Planning Application Ref: FP/142/16/DOC & FP/145/16/DOC

Location: Site 6 Phases 2,4, 5 & 5a on land north of Felpham

Description of works: Conditions 8 & 10 – Landscape Scheme

Scale
1 : 250@A0
Drawing No.
D1530.L.901

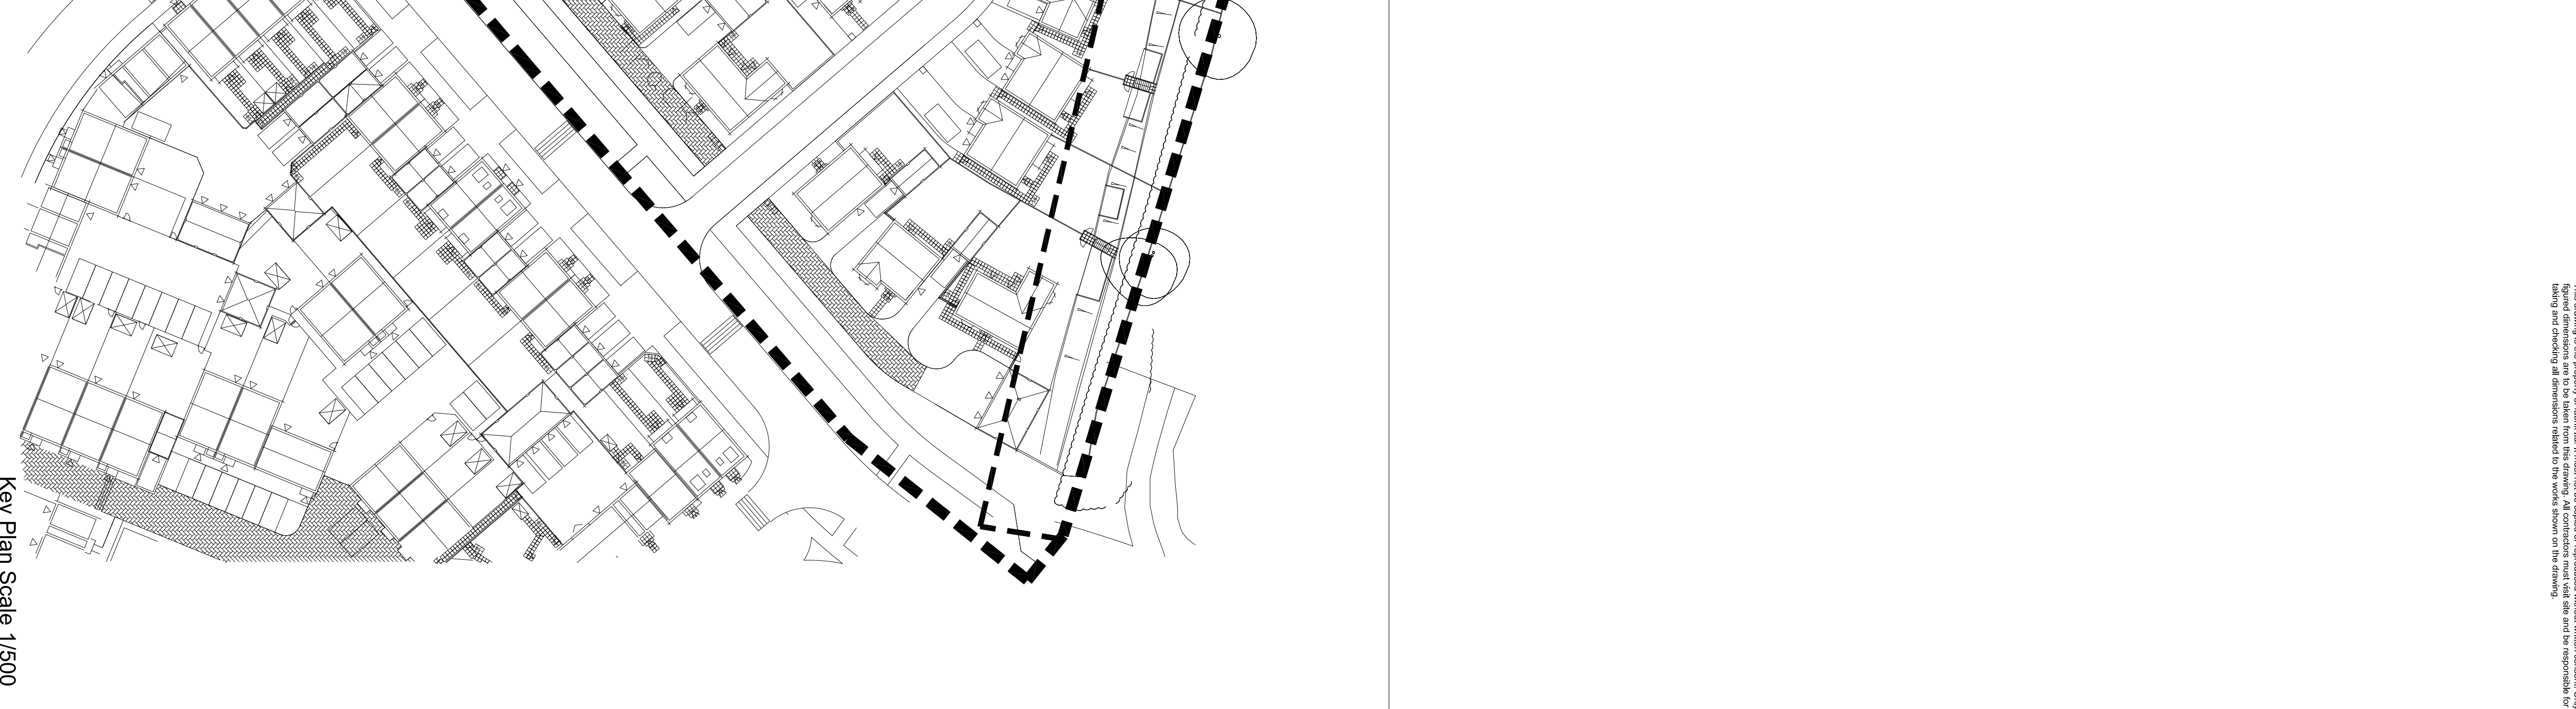
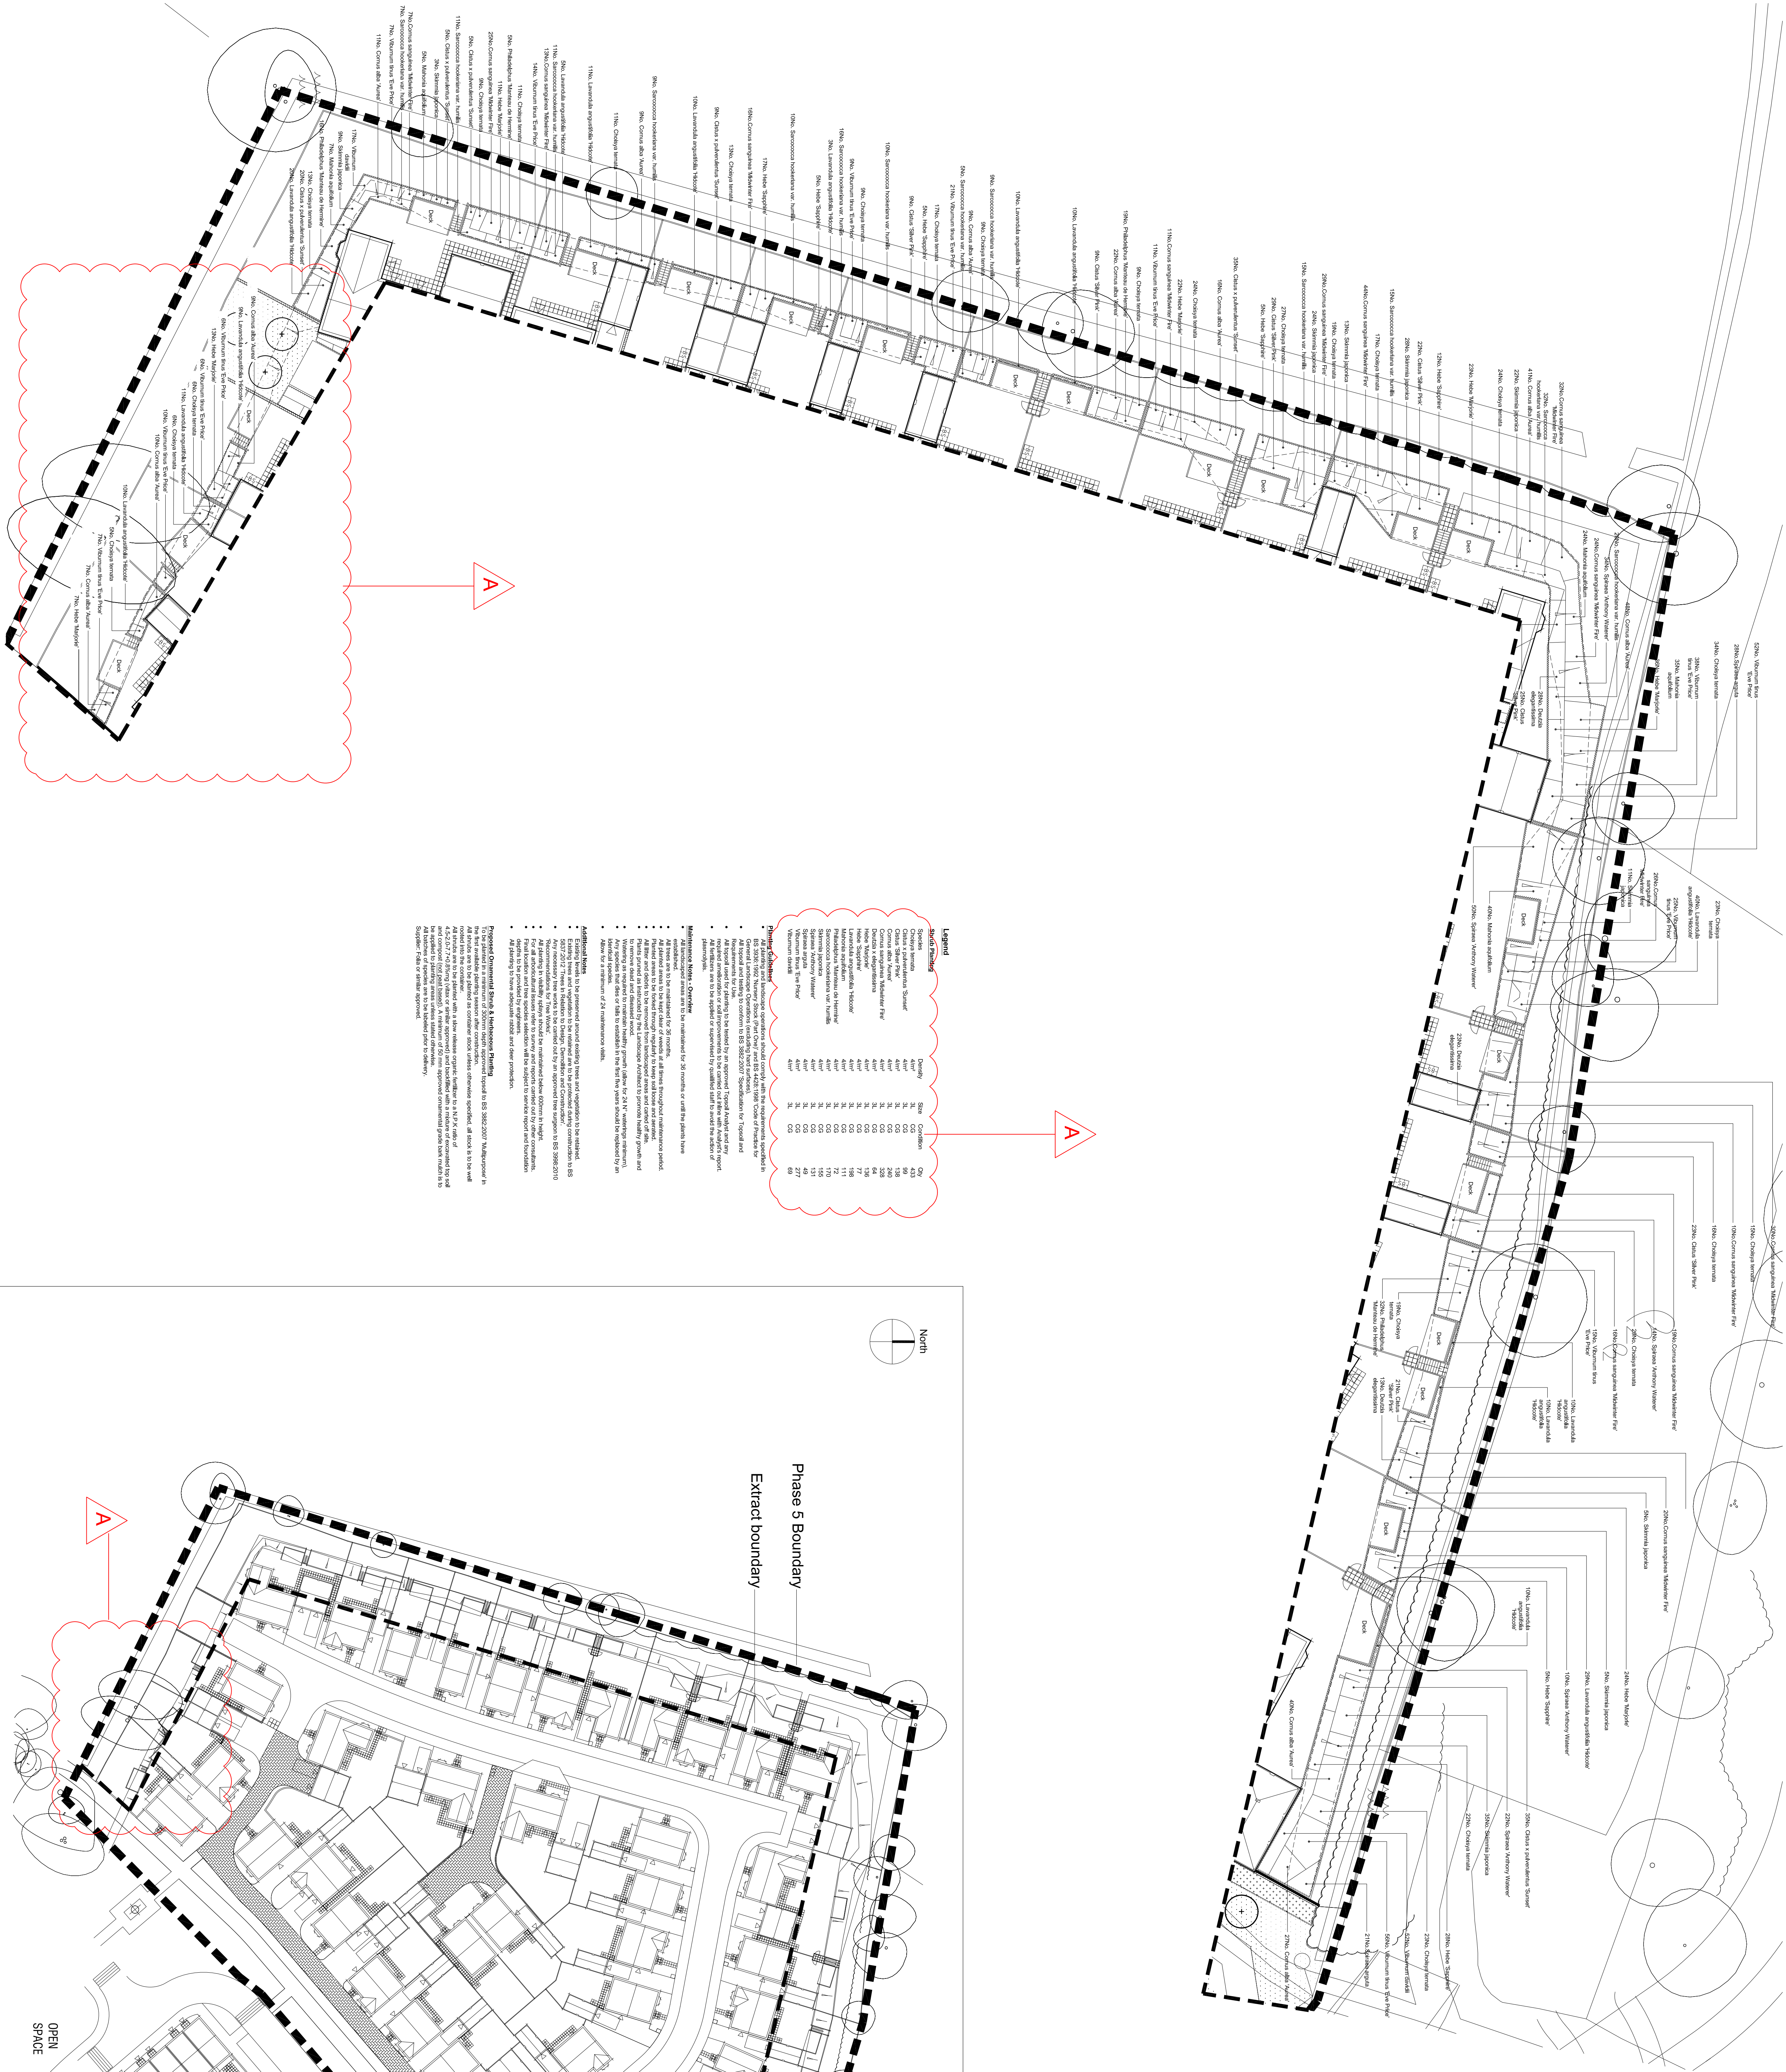
- This site is an active building site although works through this area seem to have been completed.
- The Conditions relate to Landscape Schemes so I defer to Sue Howell (Landscape Officer – Greenspace) for her comments on this.
- However, I would add that the FABRIK plans Tree Removal & Protection Plan (Sheets 1 & 2) state that the footpaths are to be of 'No Dig' Cellular Confinement system construction form whereas what I saw on site appeared to be finished paths that were tarmac hard surfaced.
- It is not possible to determine after the fact whether any root damage occurred during this process and it can take up to three to five years from completion of work for any signs of dieback to appear in trees that have suffered root damage of any sort.
